Our ref: LT/2020/124958/01-L01
Your ref: A38 NSIP
Date: 3 February 2020

**A38 DERBY JUNCTIONS - 2ND WRITTEN QUESTIONS (JANUARY 2020) FROM INSPECTOR
A38 DERBY JUNCTIONS**

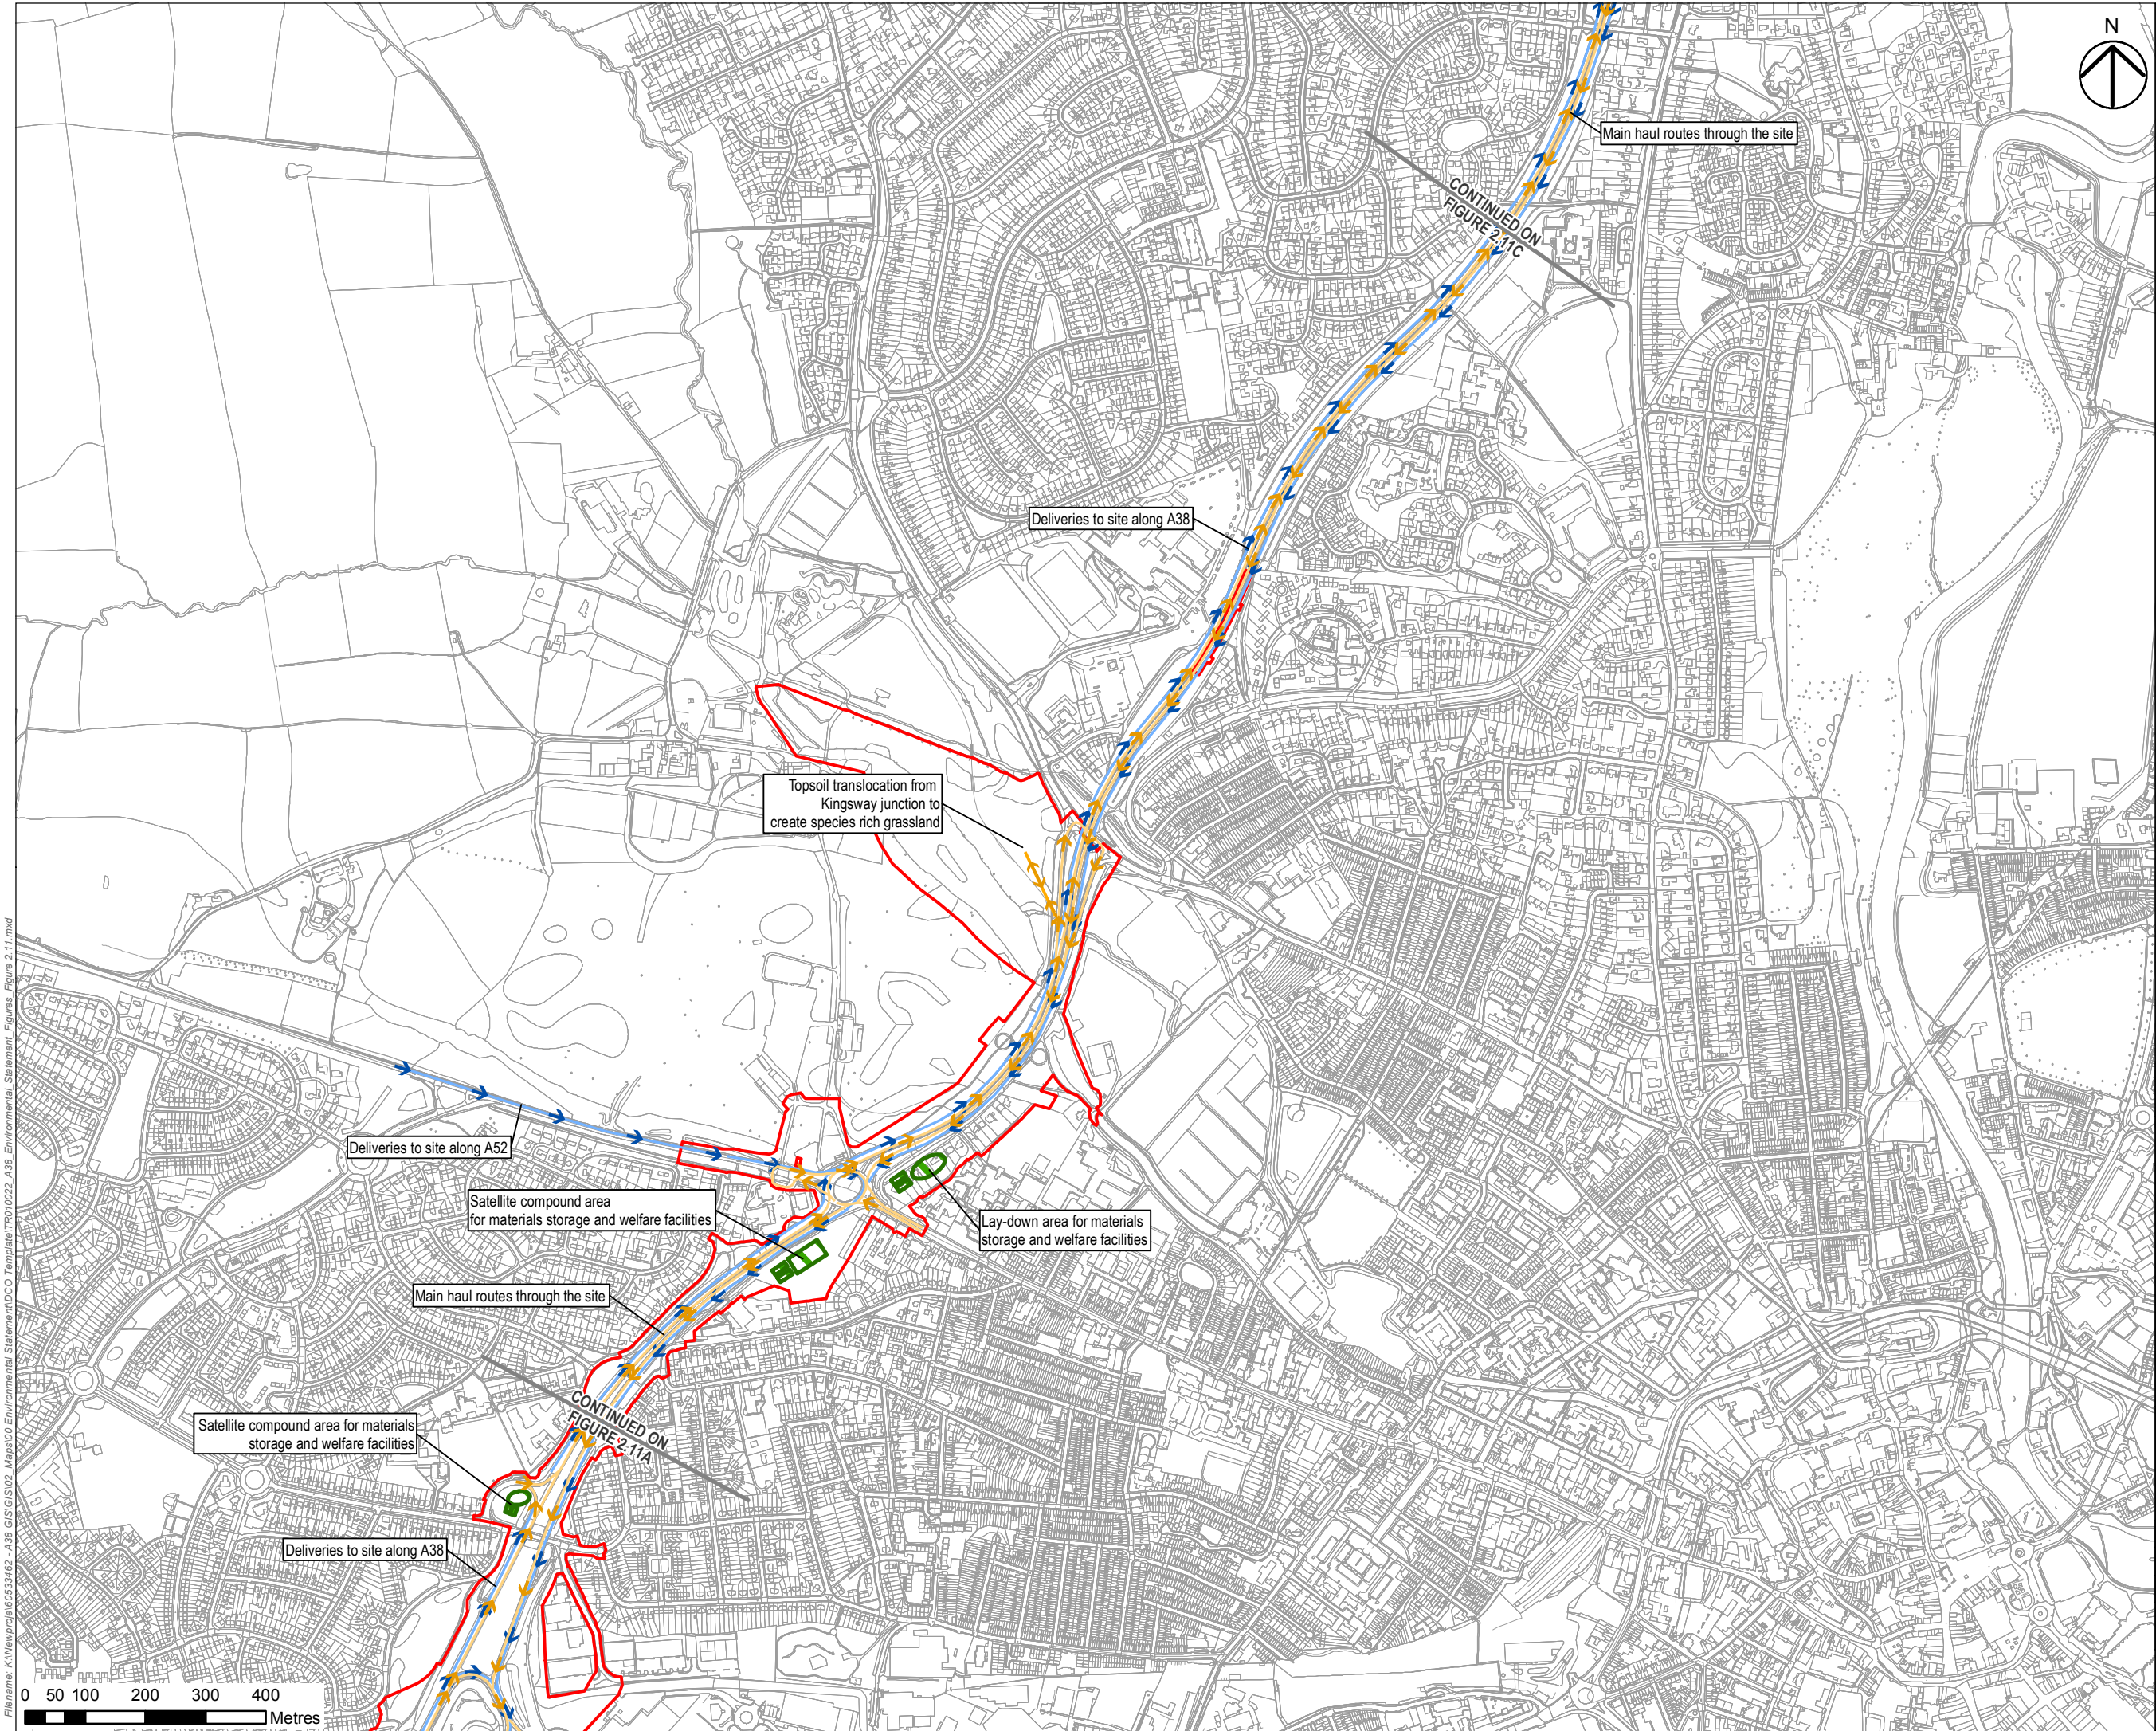
1.24 - a) We note that the proposed area of the main construction compound is situated on an historic landfill site, and within close proximity to a public water abstraction point. The compound would be located within Source Protection Zone (SPZ) 2, and very close to SPZ1 for this abstraction point. This is therefore a very sensitive location from a groundwater protection point of view.

We therefore seek within the Preliminary Works CEMP details of the drainage solution for the construction compound from the applicant, and relevant pollution prevention measures to reduce the risks of pollution to controlled waters from activities in this location (e.g. lining large parking areas or moving fuel storage locations to outside of SPZ2 etc).
